Ask for:	Erika Davies
Telephone:	01832 742207
Planning Services	01832 742073
Our Ref:	NE/21/00732/FUL
Your Ref:	
Date:	10 May 2021

Proposal : **Erection of residential dwelling (Revised submission to 20/01358/FUL) at Grange Farm Church Road Hargrave Wellingborough Northamptonshire NN9 6BQ .**

I refer to the above application received on **30 April 2021** but have to advise you that it is **INVALID/INCOMPLETE**. In order to enable further progress to be made, please supply the following:

Proposed house to rear of  
Grange Farm House , Hargrave .  
Elevations and Site Plan .  
Job N° 20/43 . Drg . N° 6 rev. 2 .  
June 2020 .

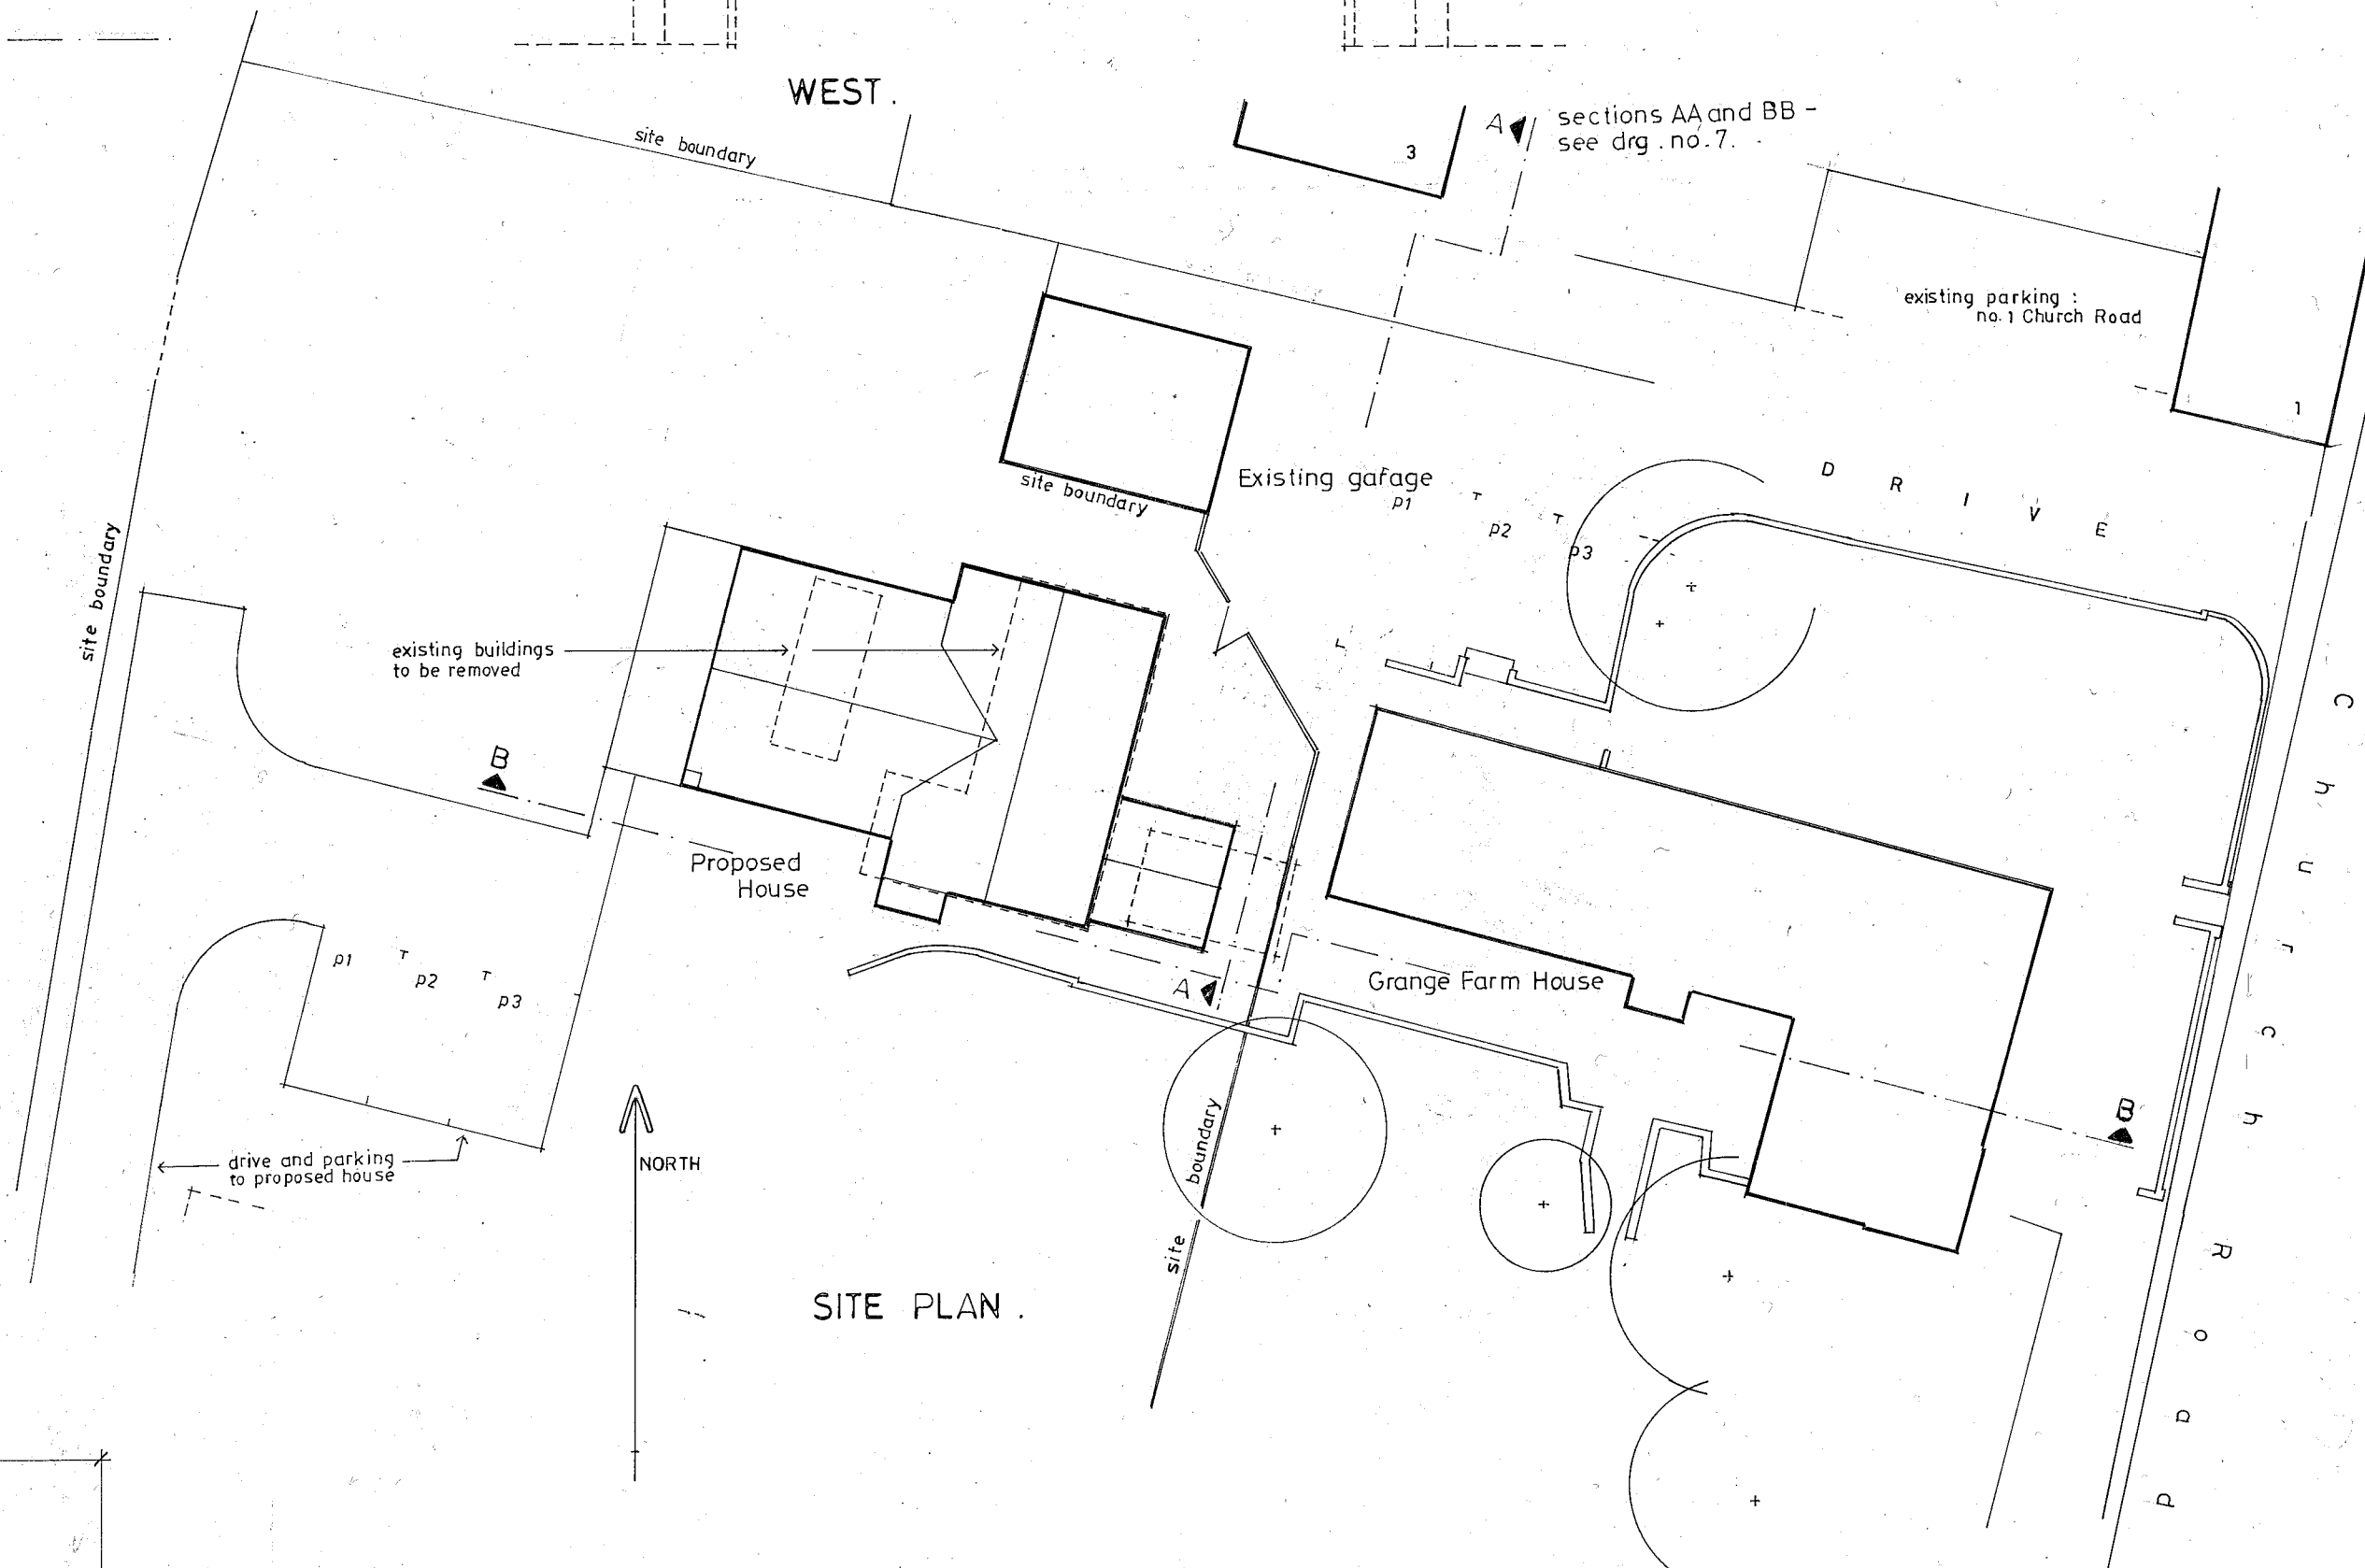
4. Thank you for the site plan submitted with your application, unfortunately it does not fully accord with our local requirements because only part of the proposed site is shown. As per our local requirements the site plan (to a scale of 1:200 or 1:500 although other scales may be more appropriate for larger sites) should show your proposals for on-site access, parking, and turning arrangements and facilities for cycle parking (where applicable); vehicle access visibility splays at the highway boundary; the extent and type of any hard surfacing; boundary treatment (including all heights and materials); and applications for new developments must include provision for the storage and collection of waste and recyclables. Please provide an amended site plan.

Marric Chartered Surveyors
Proposed house to rear of
Grange Farm House, Hargrave.
Site Plan.
Job No: 20/43 . Drg. No: 8 .
May 2021 .

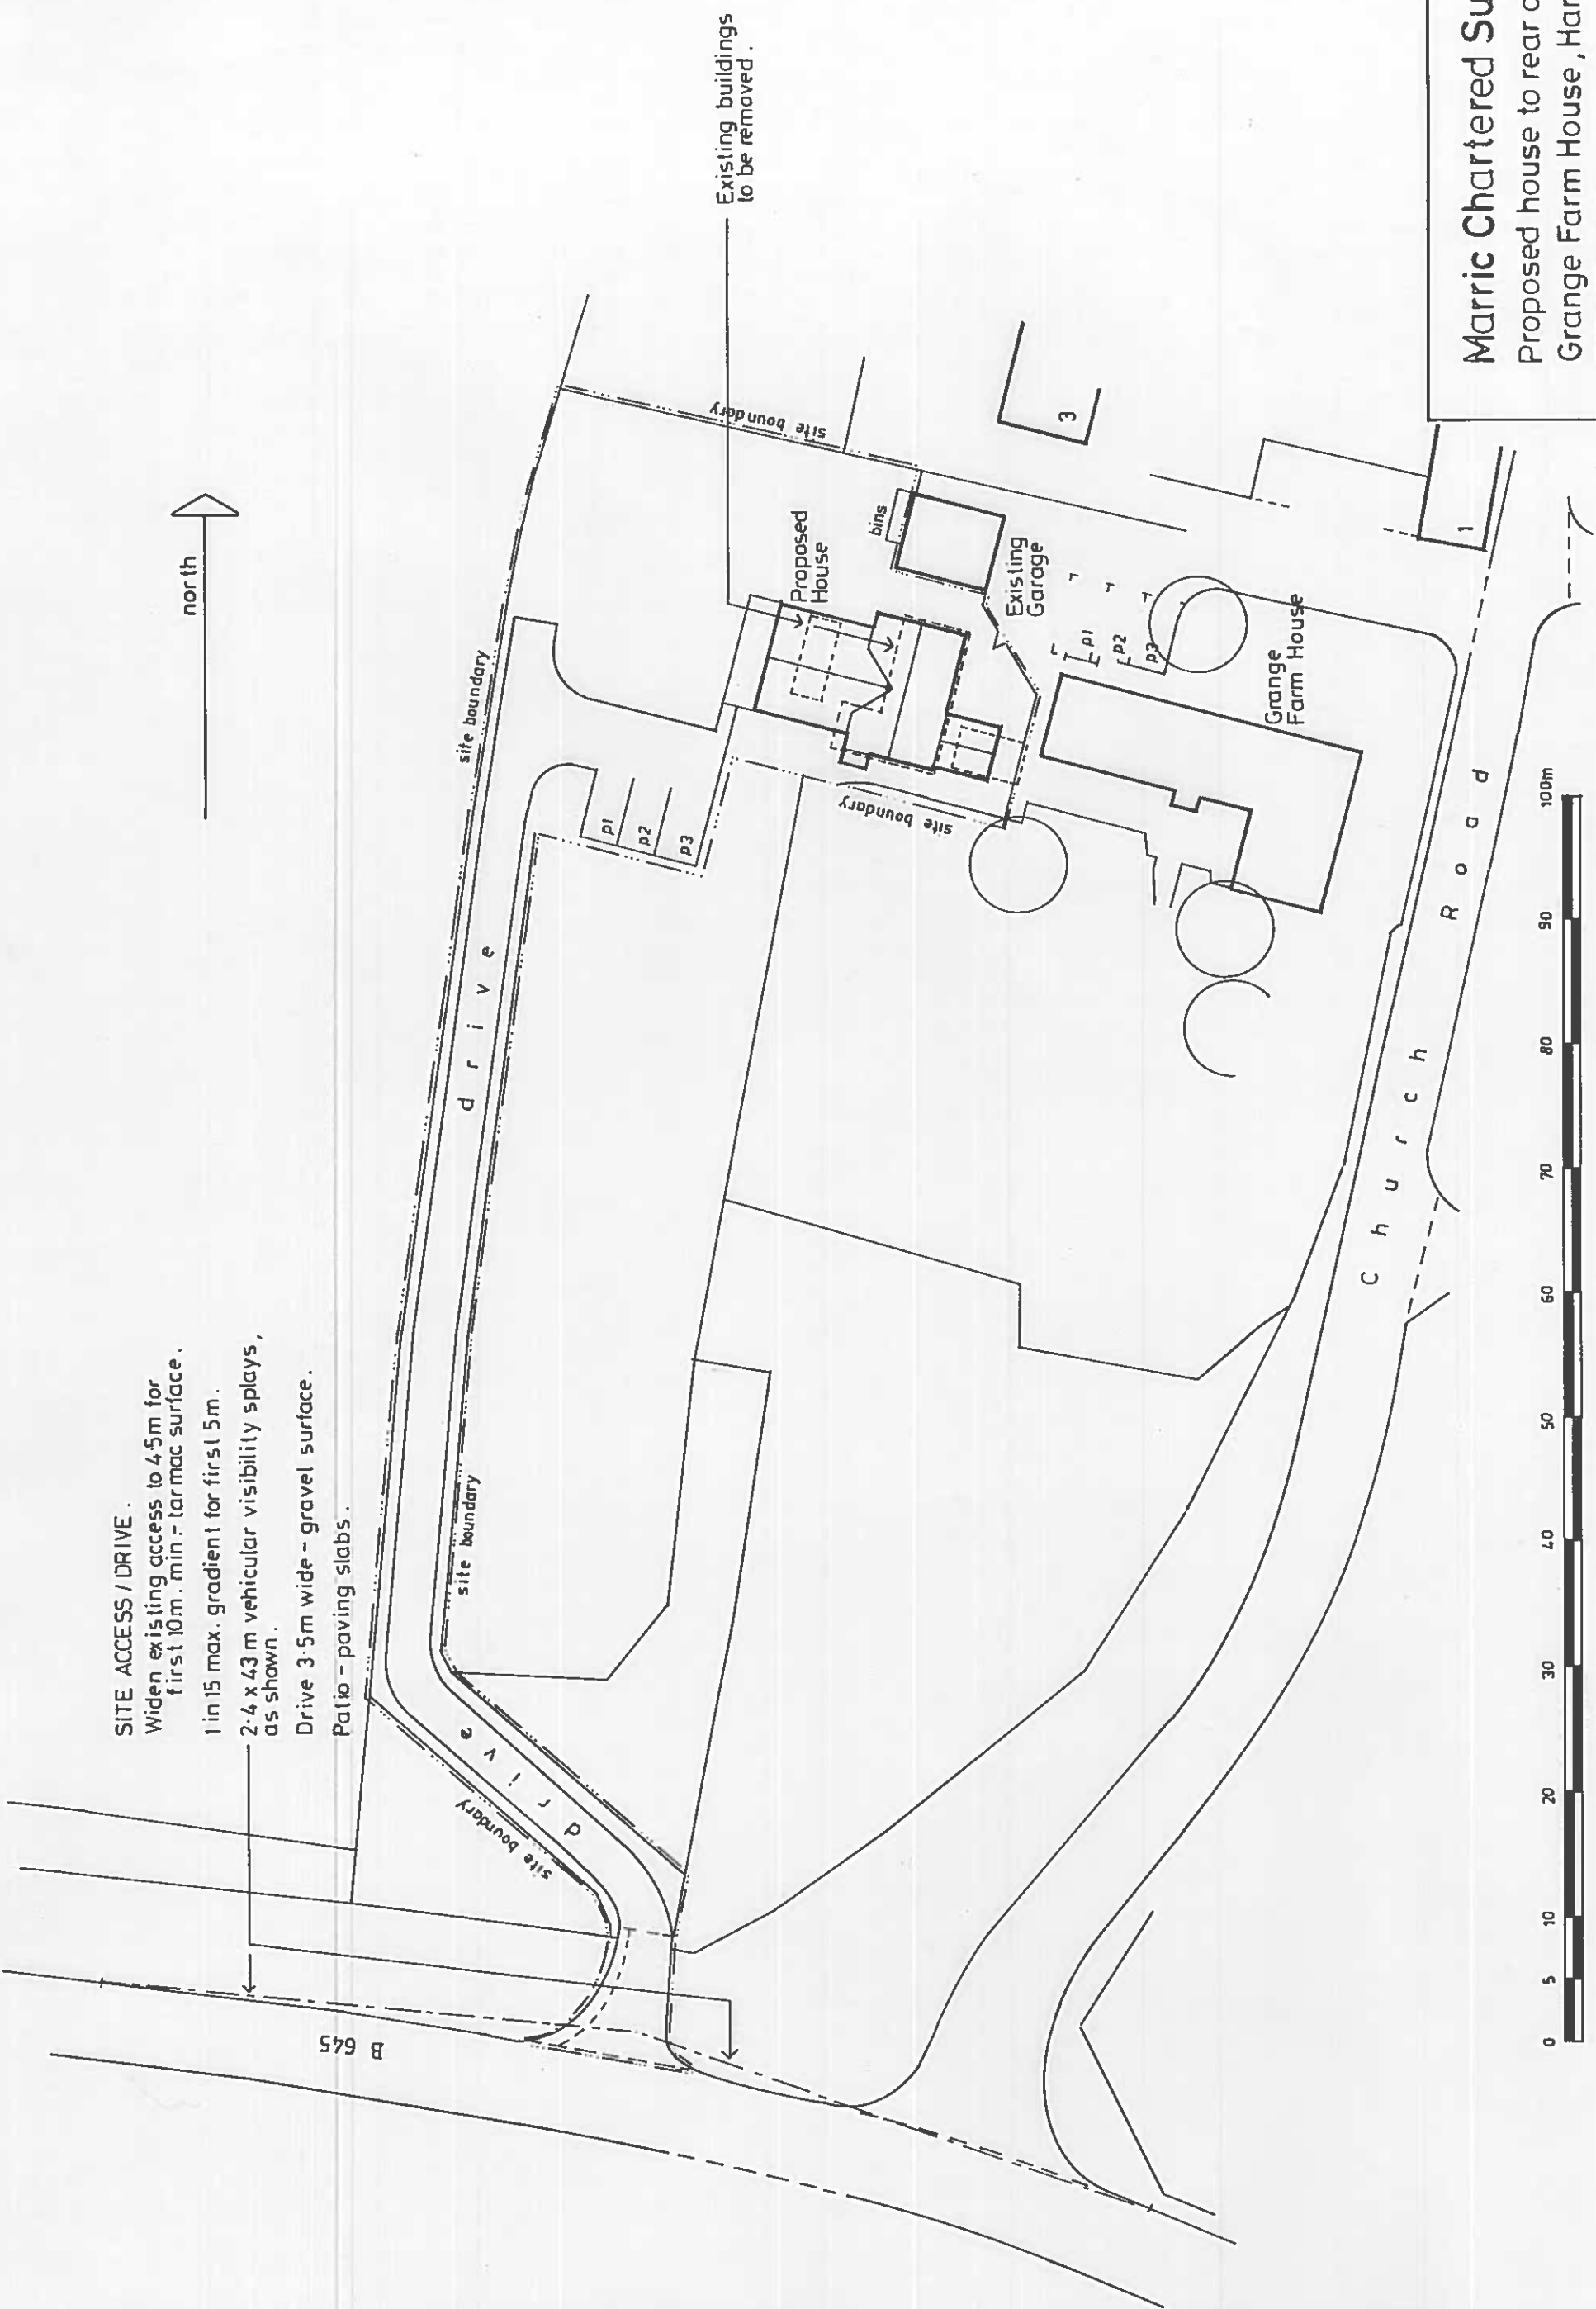
2. Whilst it is possible to provide an amended red line for the means of access, the legislation states that this must include "no other land except land included solely for the purpose of providing a different means of access". From the red line Plan provided it would appear that the proposed red line is different to that for the previous application as land on the western boundary has been included. For this reason a fee of £462.00 will be required. Please make arrangements for this payment to be made as soon as possible. You can pay on our main council website, from the "Pay for something" section

3. Thank you for the location plan submitted with your application, unfortunately it does not fully accord with our local requirements because the proposed widened access to highway has not been included on the red line. As per our local requirements the red line must also include the land required for access to the site from the public highway. Please provide an amended location plan.
